TECHNICAL NOTE

PROJECT: Land west of Pagham Road – Approval of Reserved Matters (planning references: P/155/21/RES and P/158/21/RES)

REPORT: 2152/TN/03 – Response to highway officer consultation dated 30th November 2021

DATE: December 2021

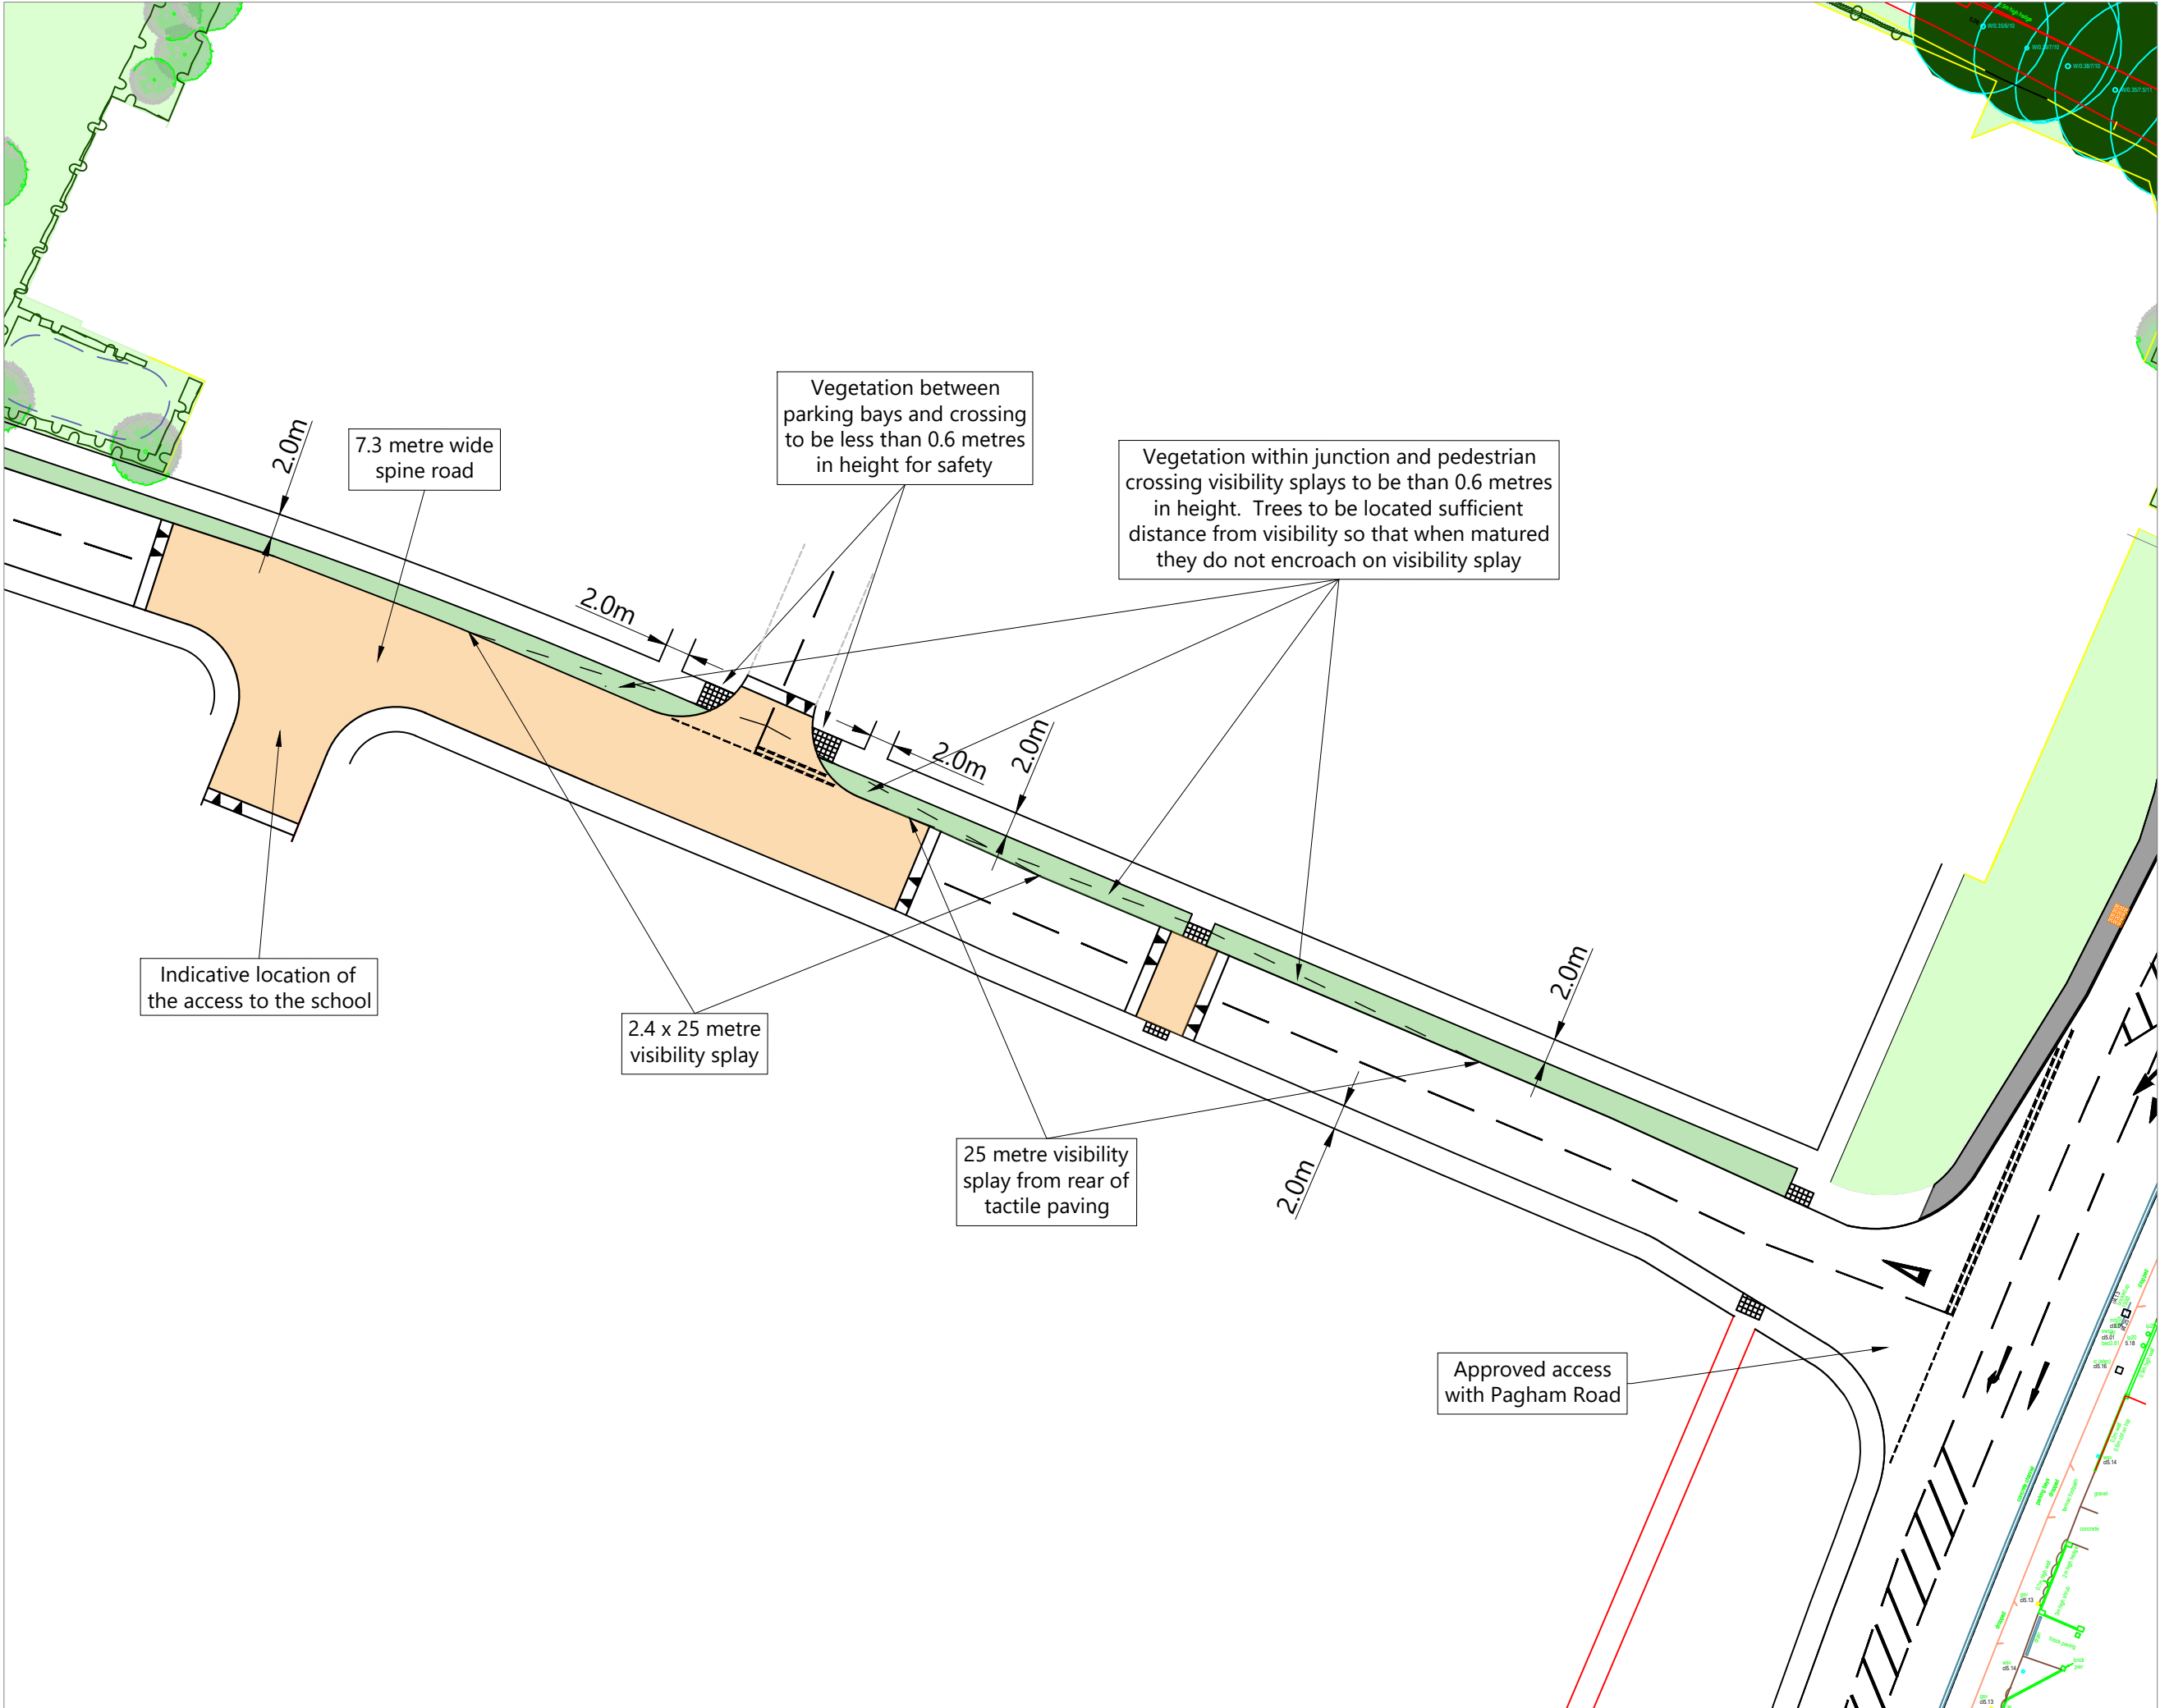
- iv. The proposed raised tables on this section of the spine road should be reviewed.
 - v. A servicing management plan for the retail uses should be secured by means of a planning condition.

It's also recommended that the single raised feature to the west of the raised feature incorporating the community uses and school accesses are combined to form a single feature across the school/community use frontages. The single short raised feature in isolation serves little purpose particularly given it's close proximity the longer raised table.

15. It is understood that the highway officer is referring to the raised crossing to the east of the main raised table. The raised table to the west of the main table is intended to ensure speed are kept low between the local centre/school and the wider residential development to the west.
16. A plan of the updated access proposals (HTp/2152/07/D) combining the main and eastern raised tables is provided at **Appendix 3** with an extract at **Figure 1**.

- Visibility splays of 2.4 x 25 metres which are conducive with the 20mph speed restriction along the spine road.
18. It is therefore concluded that the proposed raised table arrangement is appropriate and will be effective at reducing vehicle speeds.
